# PLANNING BOARD REPORT PORTLAND, MAINE

**Six unit Commercial Building**  
421 Warren Avenue  
Final Level III Site Plan  
Project ID 2014-016 CBL 296-A006001  
PH Warren Avenue, LLC, Applicant

Submitted to: Portland Planning Board  
Public Hearing Date: May 27<sup>th</sup>, 2014

Prepared by: Jean Fraser, Planner  
Date: May 23<sup>rd</sup>, 2014

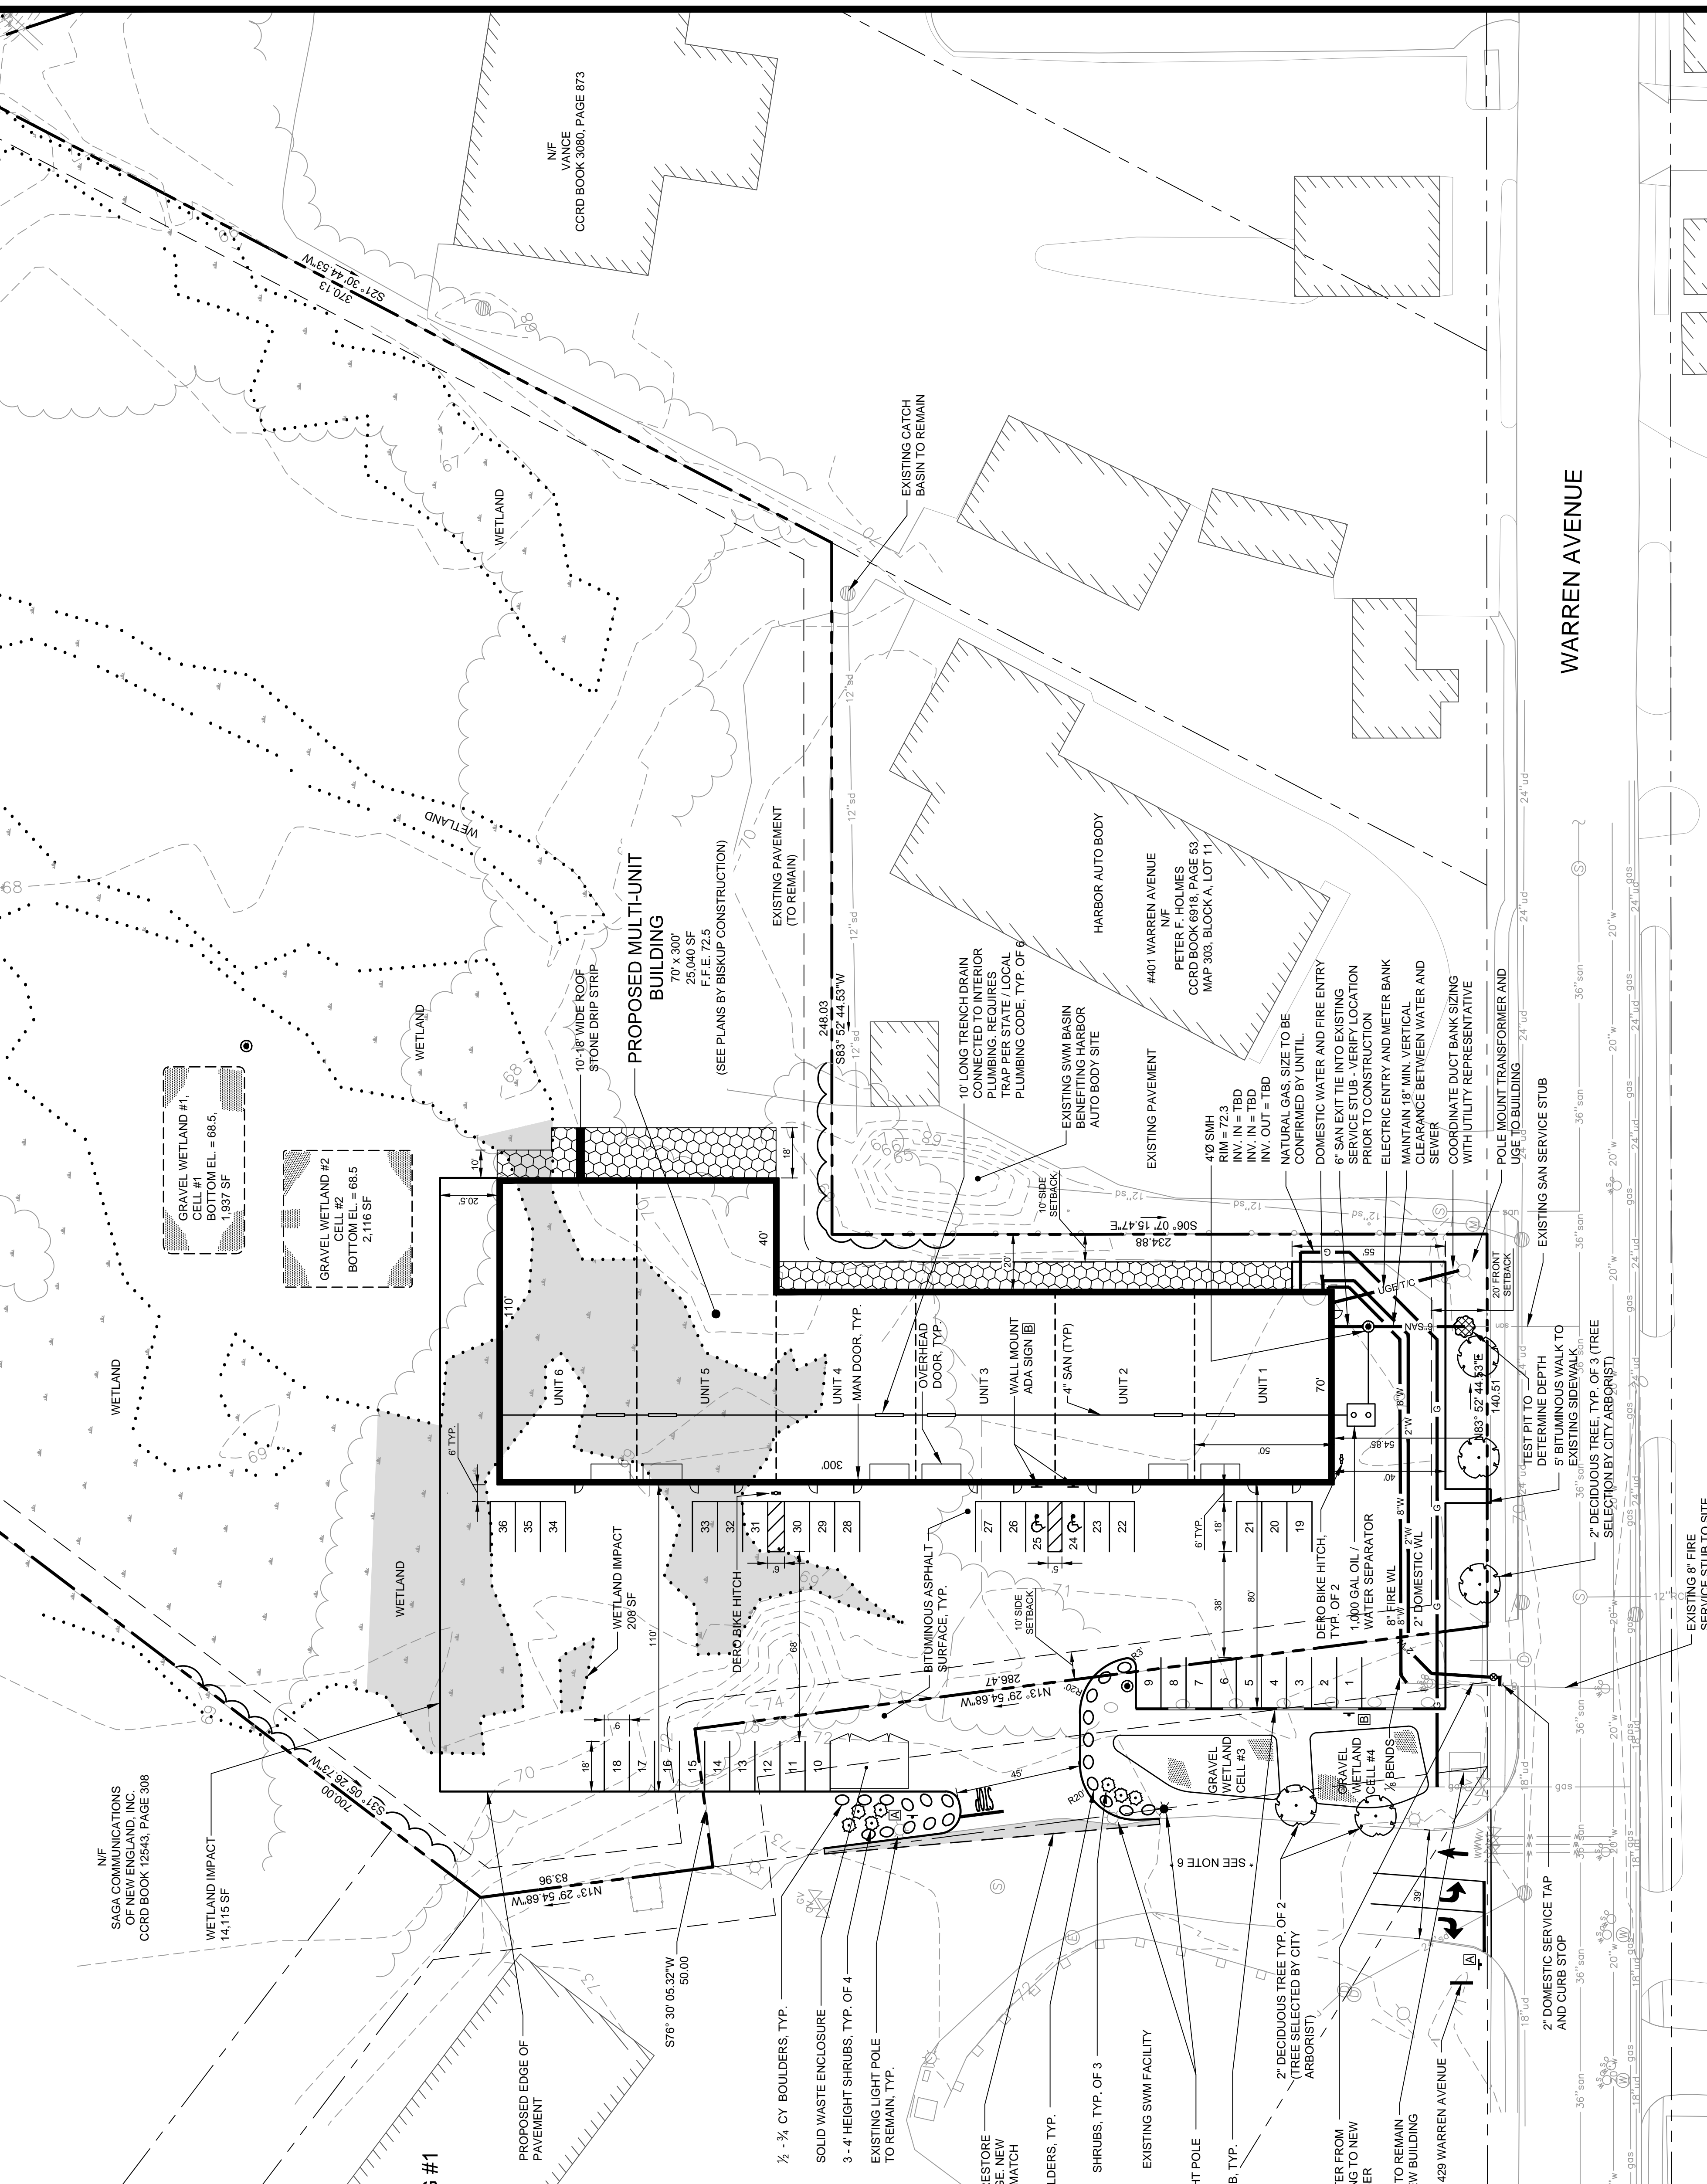
The revised proposals include the pedestrian connection from the new building to the Warren Avenue sidewalk, but have not indicated the painted marking for the pedestrian route along the front of the building and across to the pedestrian link. A potential condition of approval has been included, at Mr Errico's recommendation, to include the painted markings for the pedestrian route.

The site plan (Plan P6) does not specifically call out snow storage. The proposed paved area is likely to provide adequate area for snow storage, but the proposed wetland cells, swales and erosion control features about the paved area and a Snow Storage Plan is required to ensure that these areas are not used for snow storage. A potential condition of approval requests that snow storage areas be shown on the requested Landscape Plan.

The applicant has agreed to close this curb cut in the submitted narrative (Attachment L) but it is not shown on the plans. A suggested condition of approval requests this be shown in the site plan in Plan P6.

REV	DATE	DESCRIPTION	REVISIONS
3	07.03.14	FINAL PLAN SUBMISSION TO CITY PER CONDITIONS OF APPROVAL	
2	04.17.14	FINAL PLAN SUBMISSION TO CITY	
1	02.10.14	SUBMITTED TO CITY OF PORTLAND

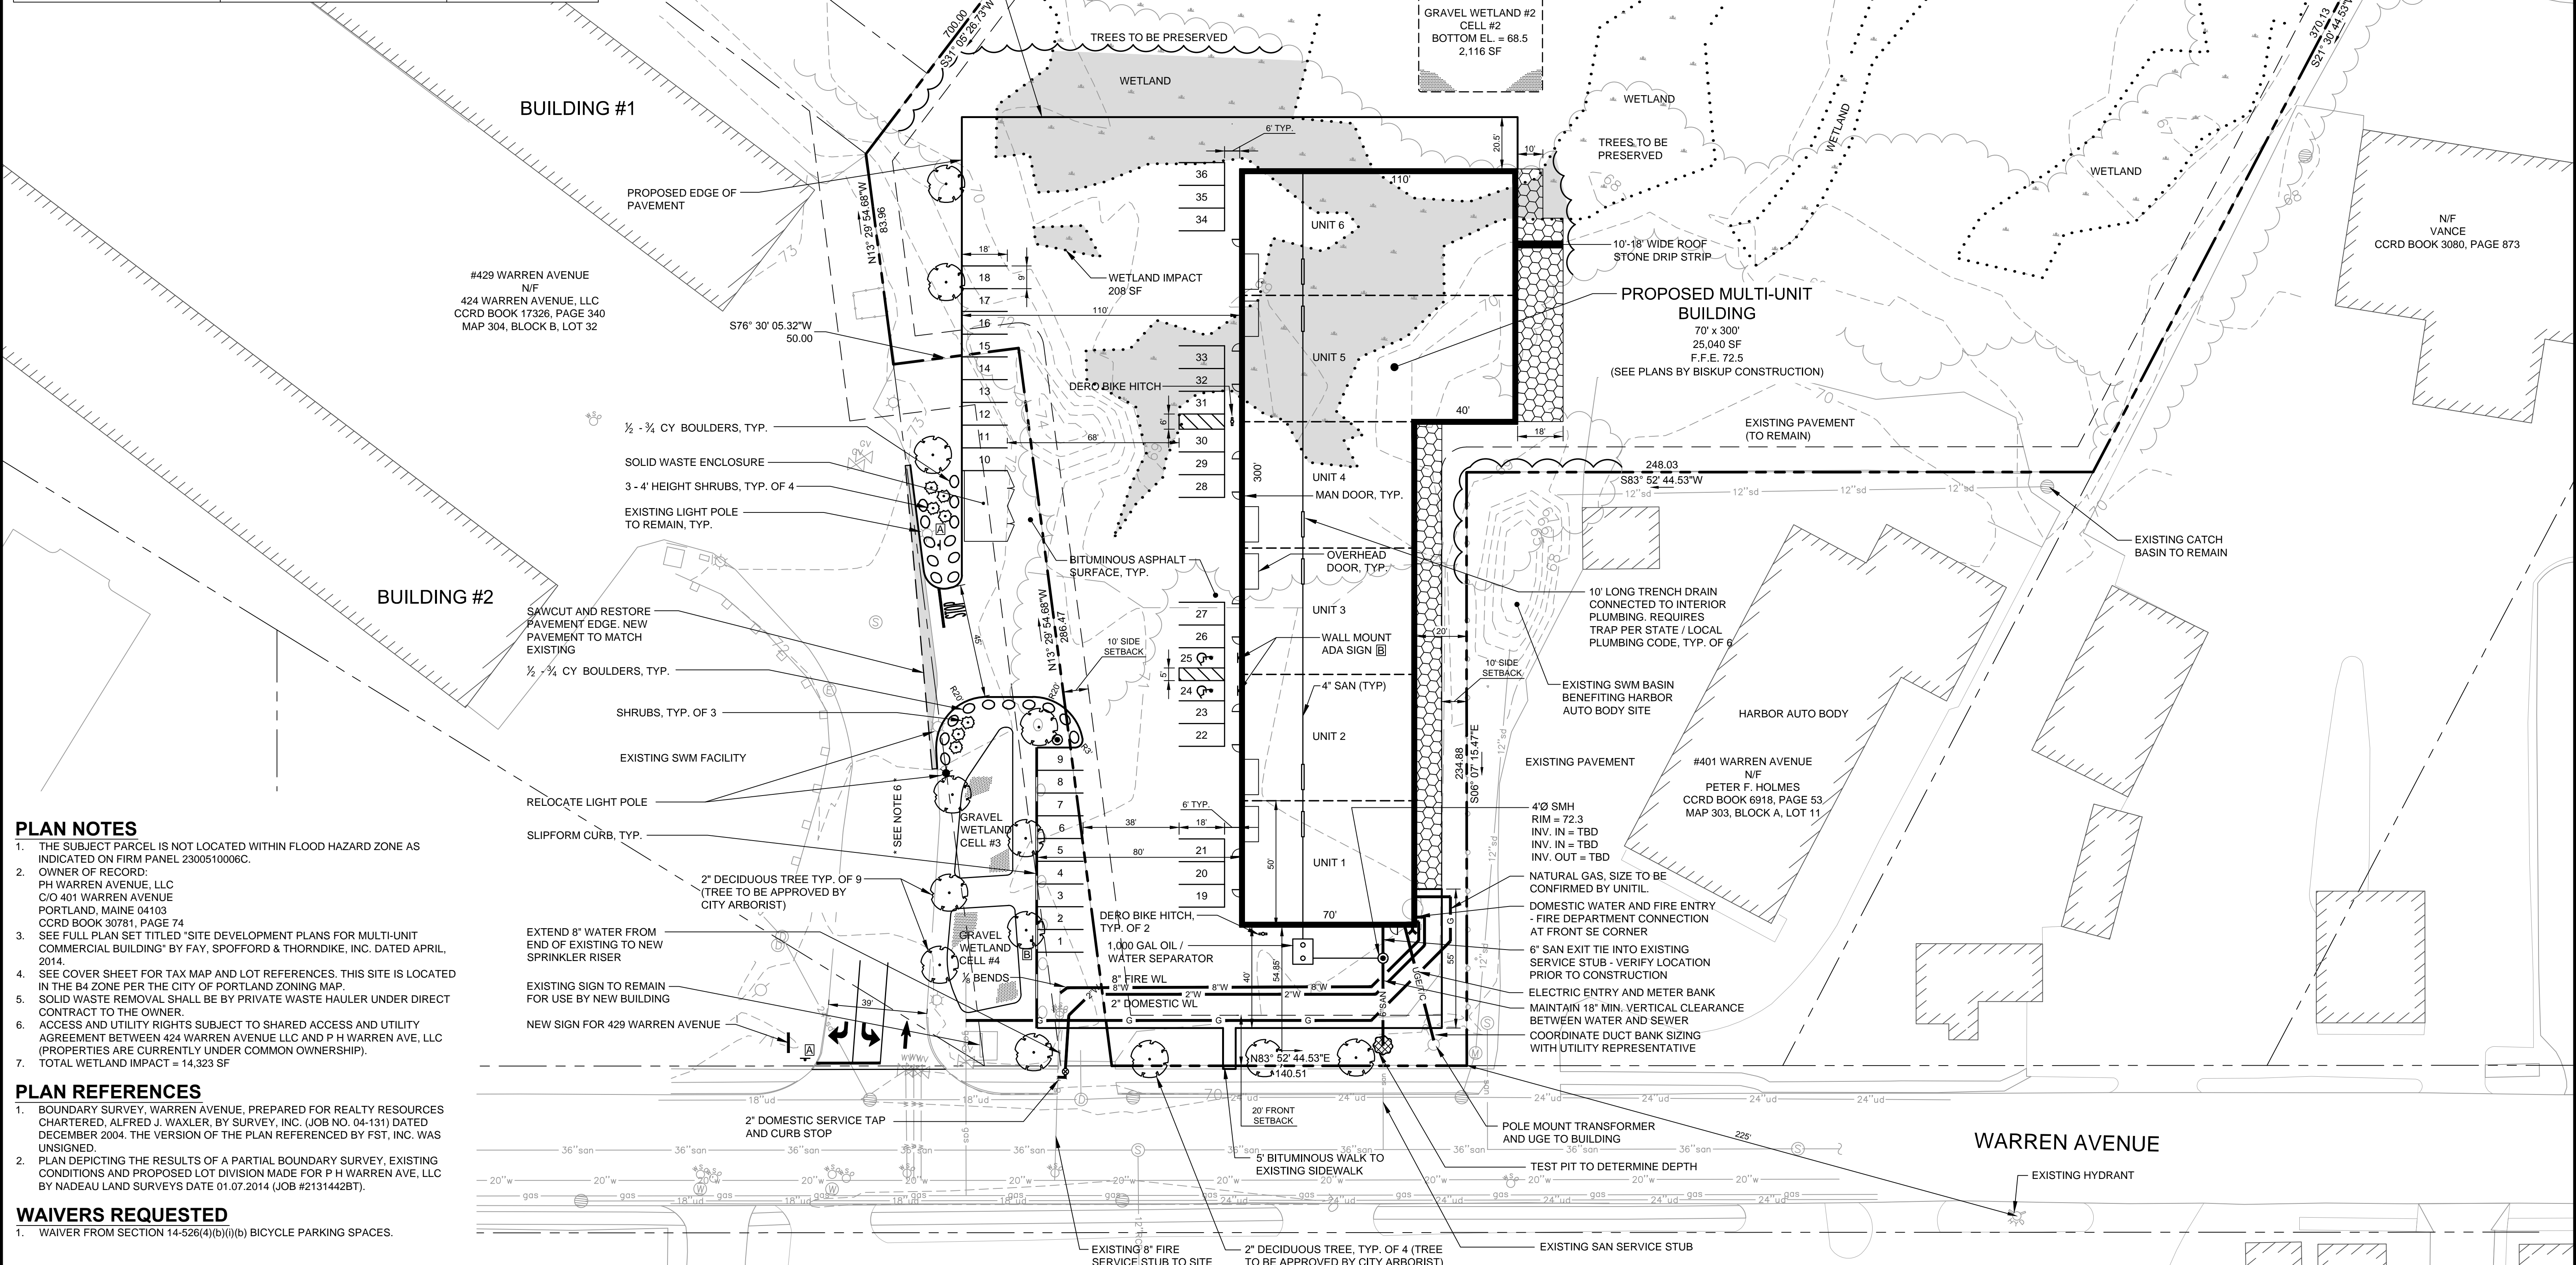
- ii. That the applicant shall submit a Landscape Plan, based on an a submitted assessment of the trees on the site, that shows the following: tree saves; any required replacement planting; and additional planting; snow storage areas; all to address the landscape preservation and parking lot landscaping requirements of the Site Plan Ordinance (14-526), for review and approval by the Planning Authority and City Arborist; and
